FOSSE GREEN SOLAR FARM – DEADLINE 5 SUMMARY

Submitted by: Philip Heard MBE MSc BSc CEng FRAeS FIMechE (IP Ref: [REDACTED])

Figure 11-3

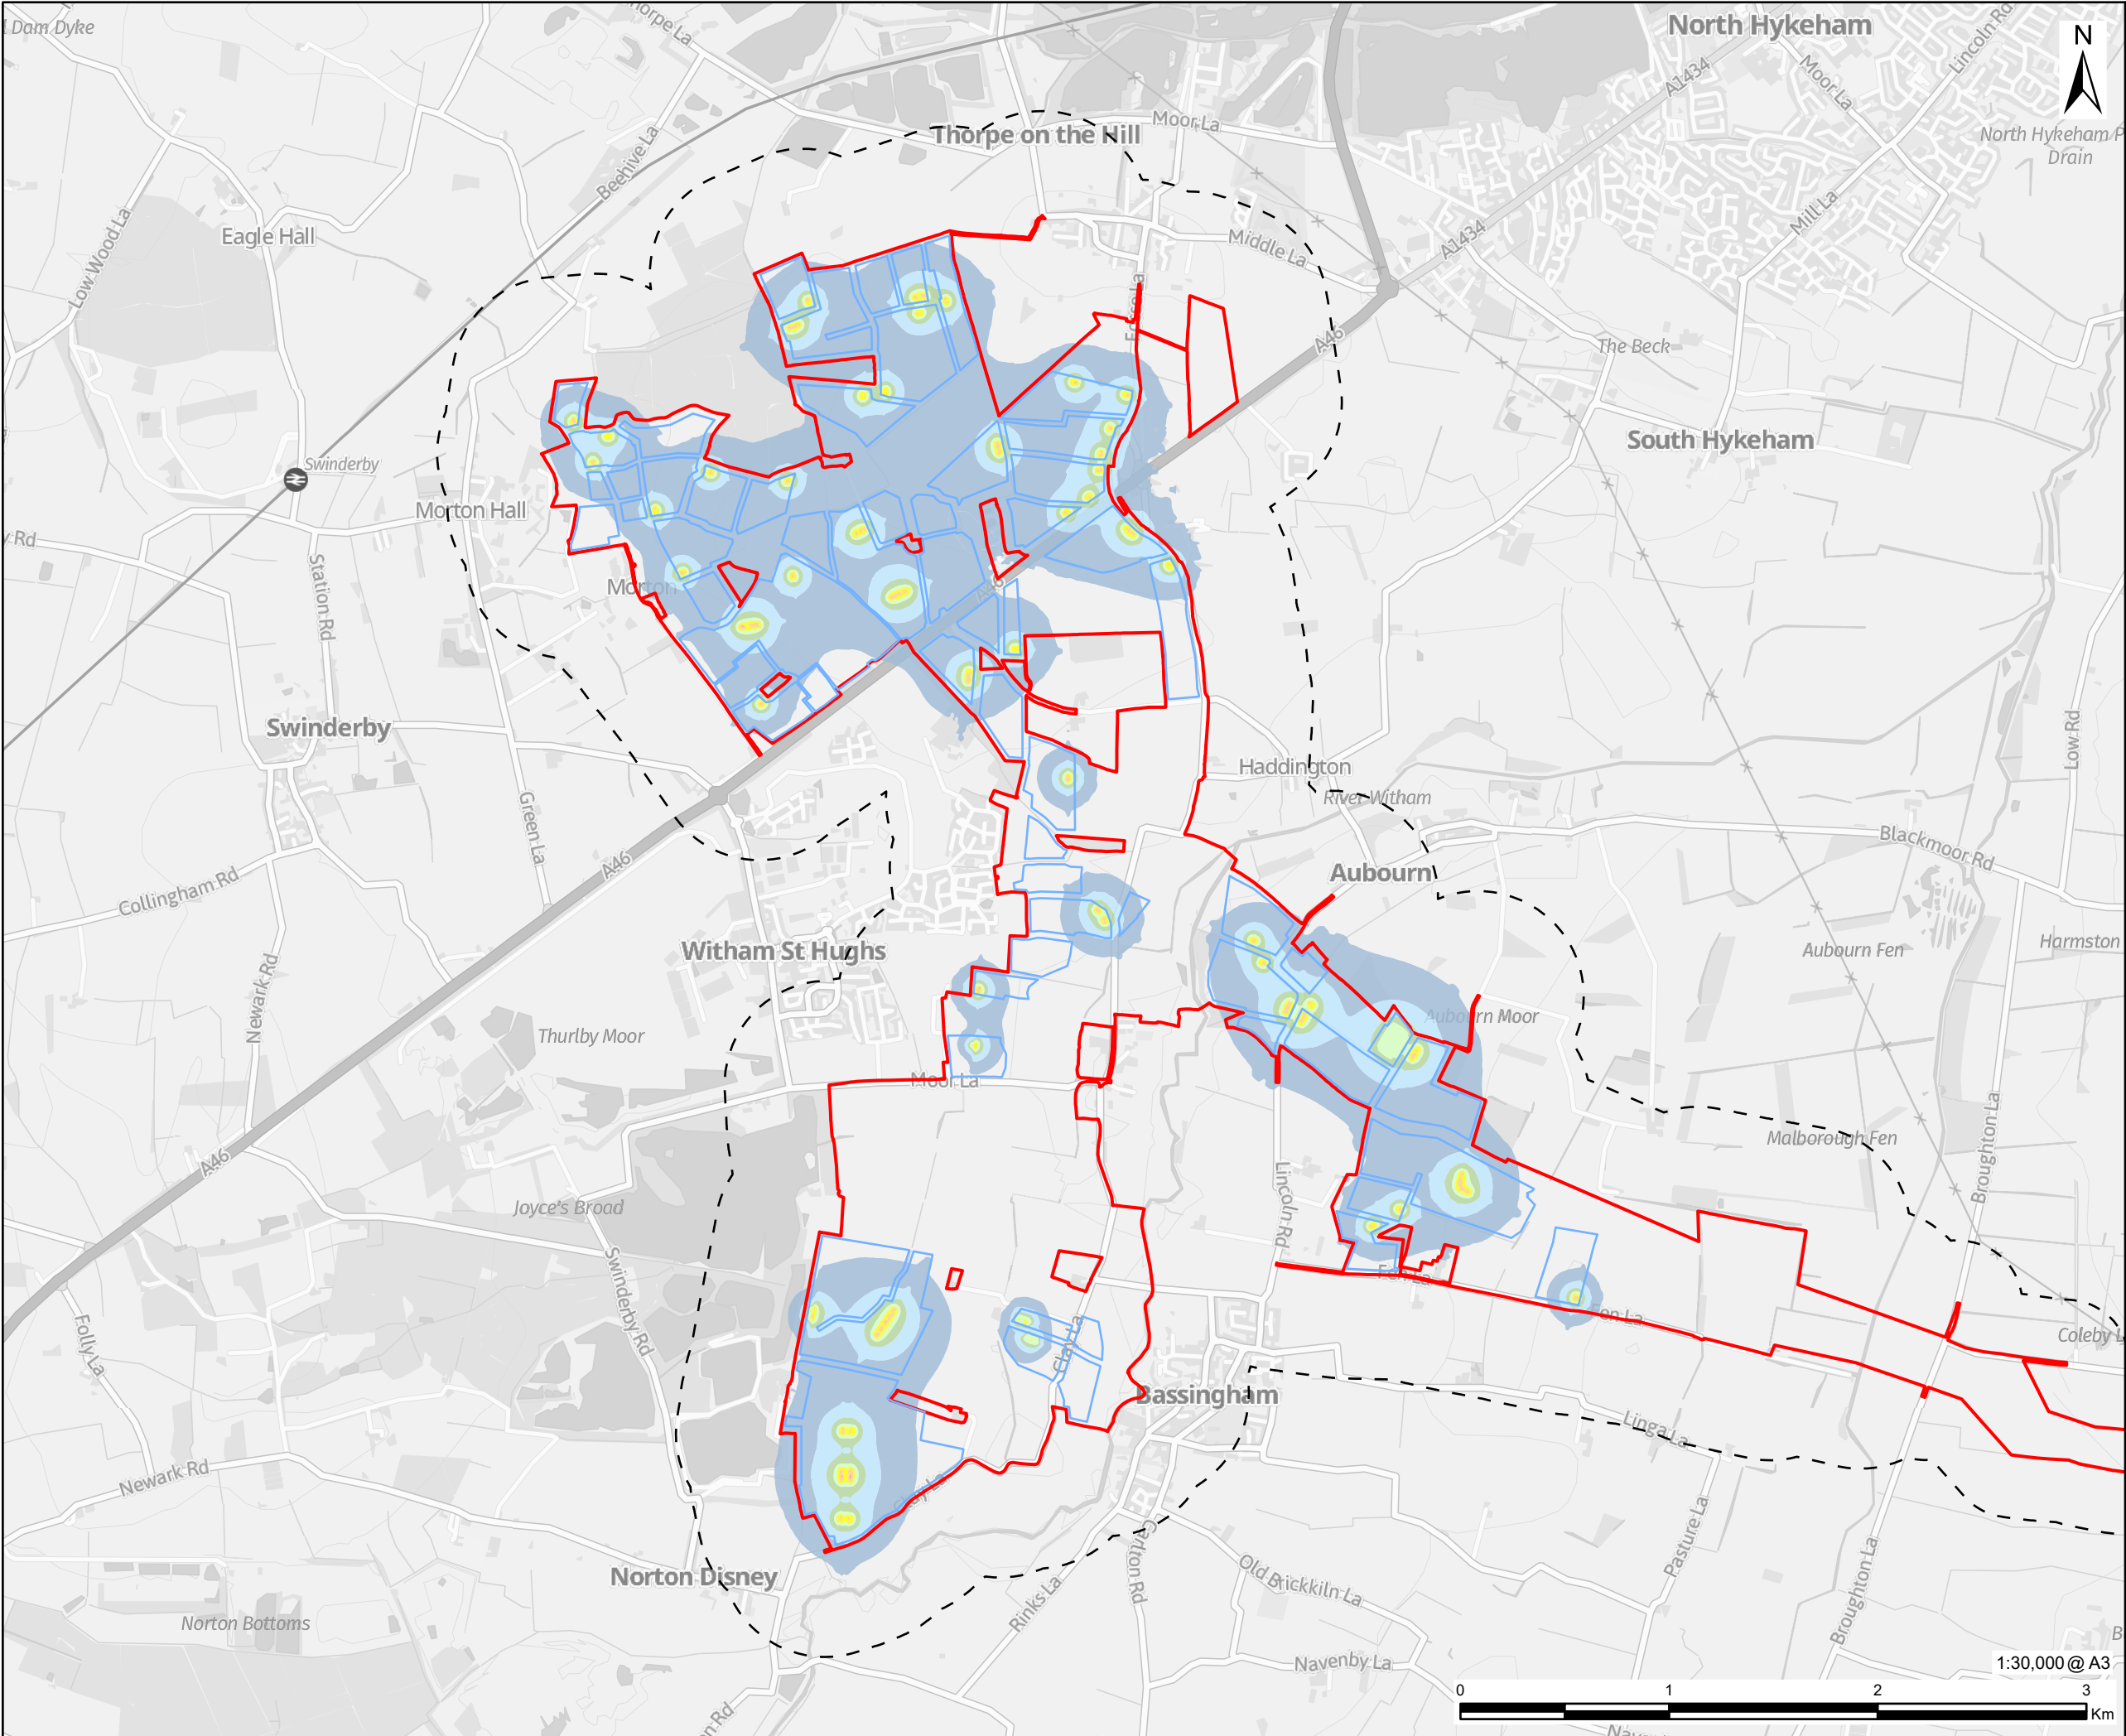
The Applicant refuses to model propagation beyond a single container, contrary to real-world events and Rochdale Envelope principles.

The Applicant incorrectly states PRoWs are not noise receptors. The submission cites national policy requiring protection of amenity and tranquillity, and notes Mallard Pass (same promoter) treated PRoWs as receptors.

Figure 15-4

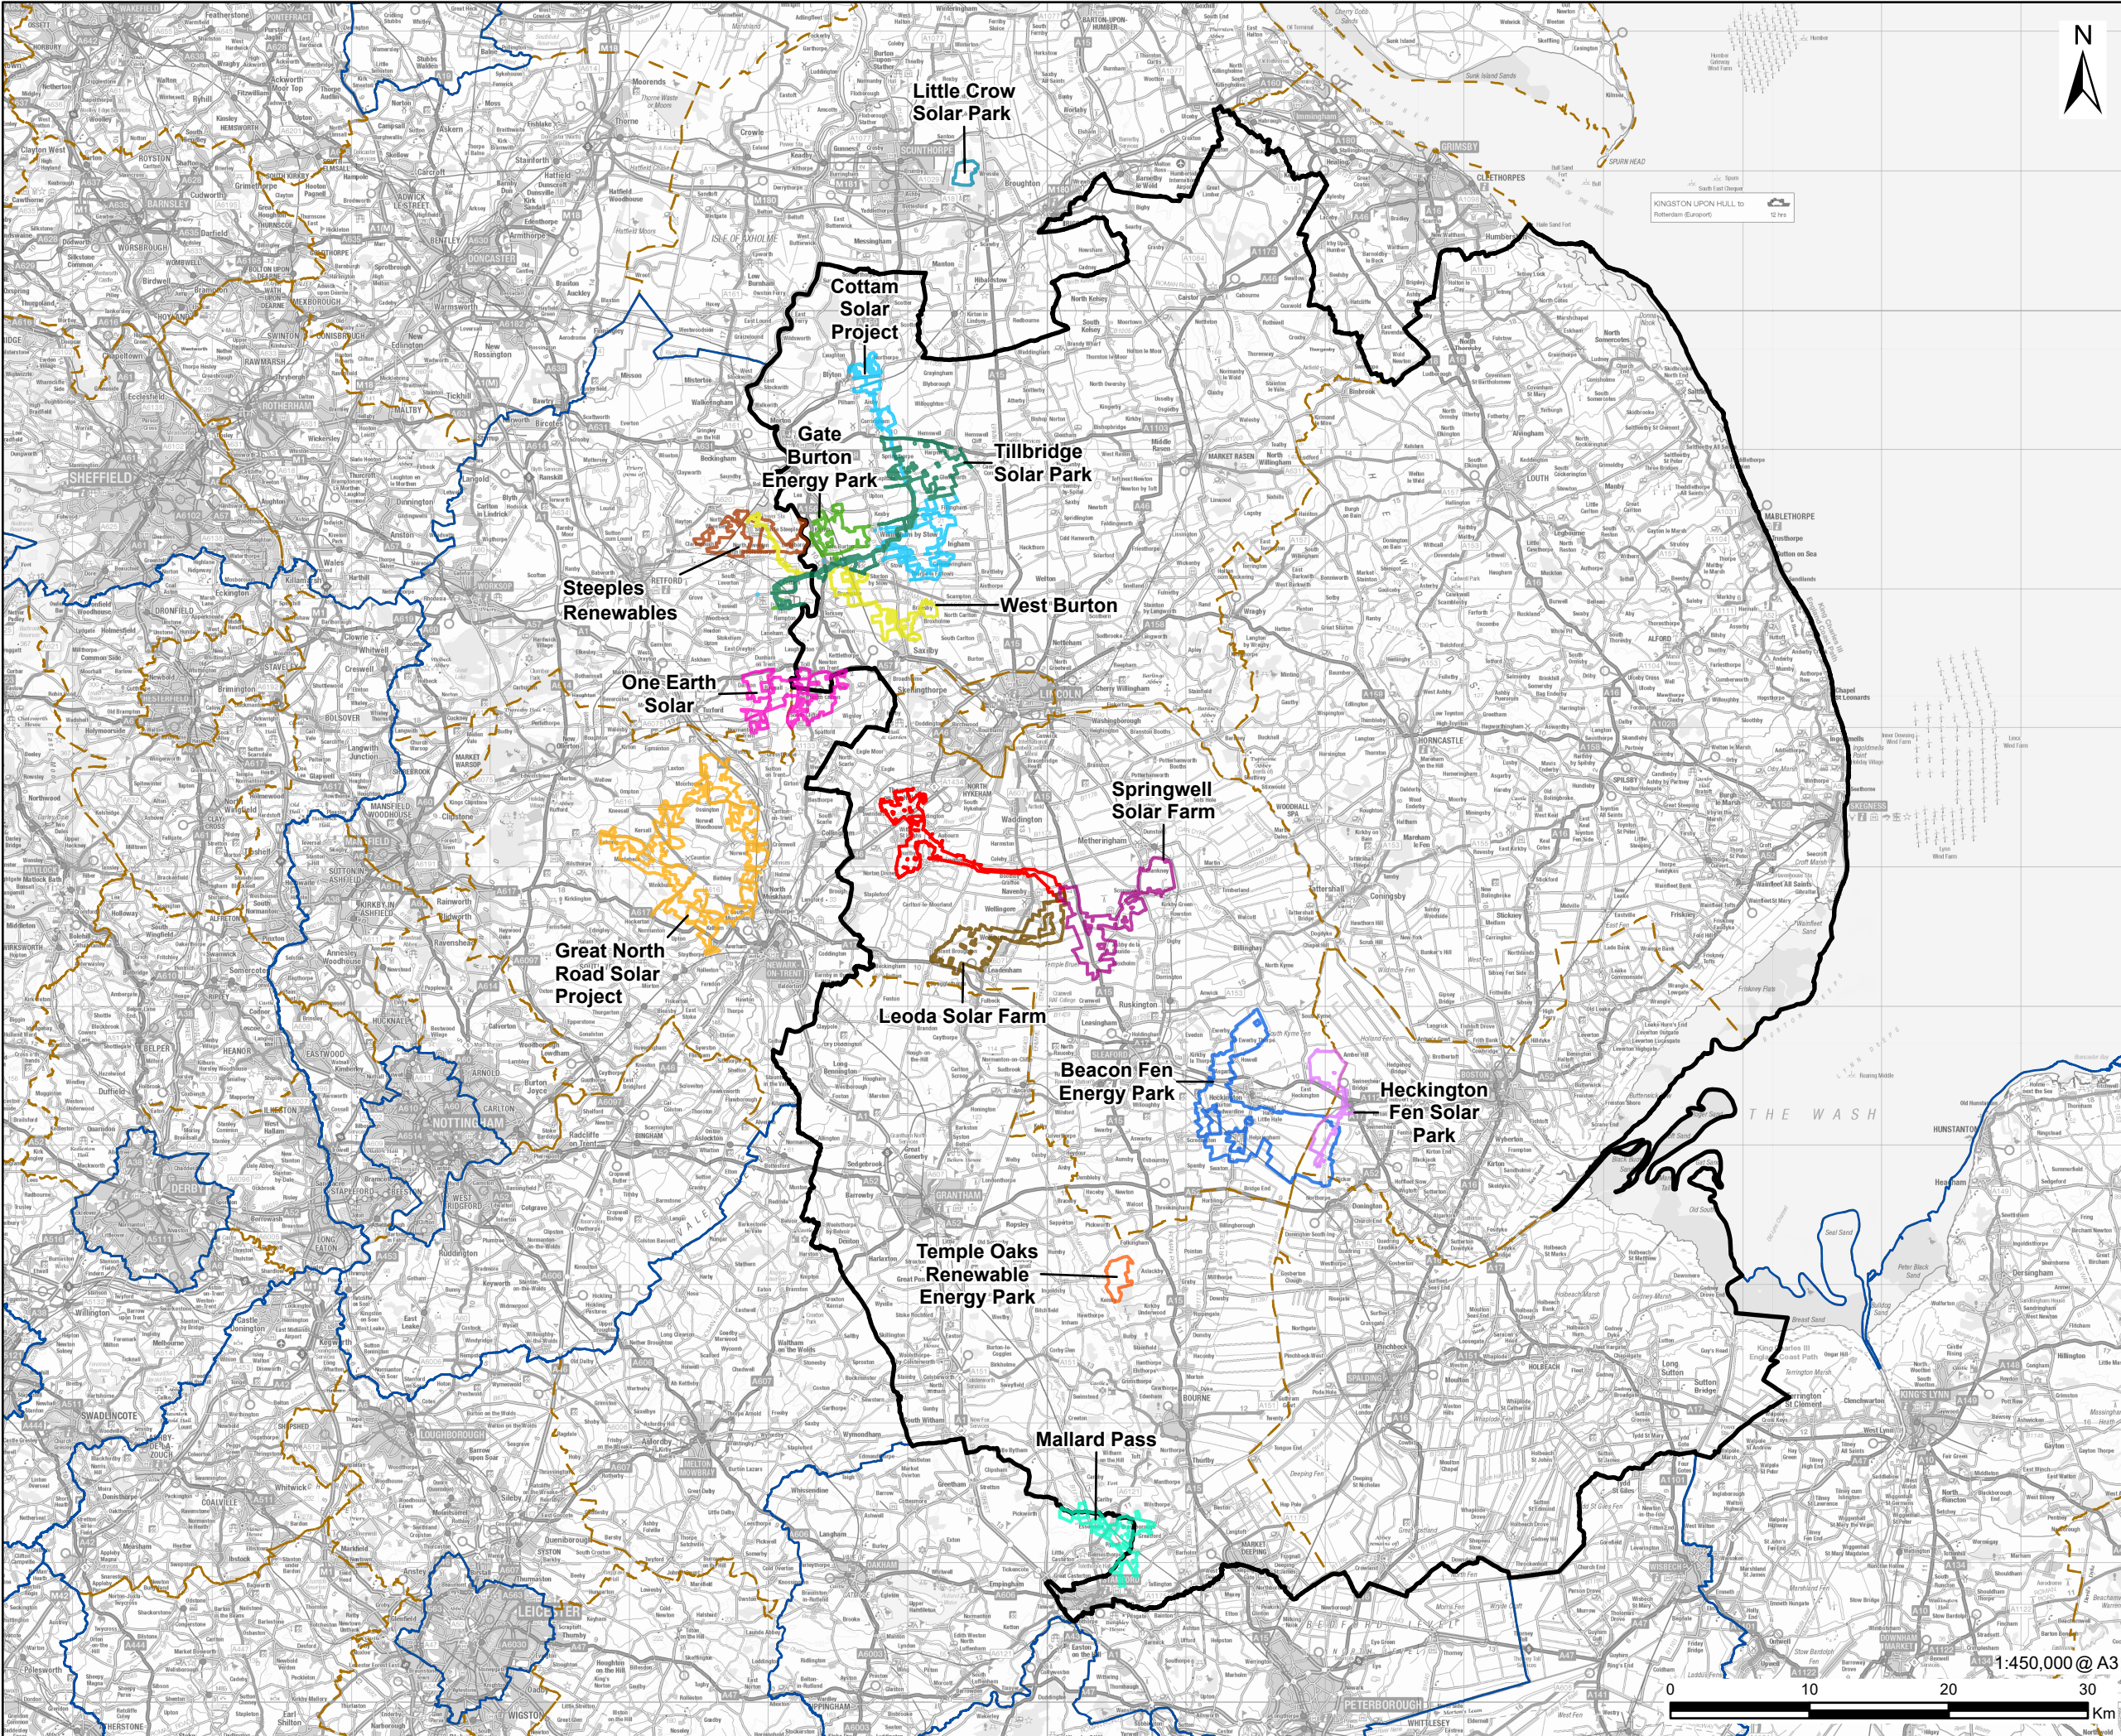
The Springwell decision letter recognises the growing cumulative impact across Lincolnshire. Fosse Green would materially worsen this.
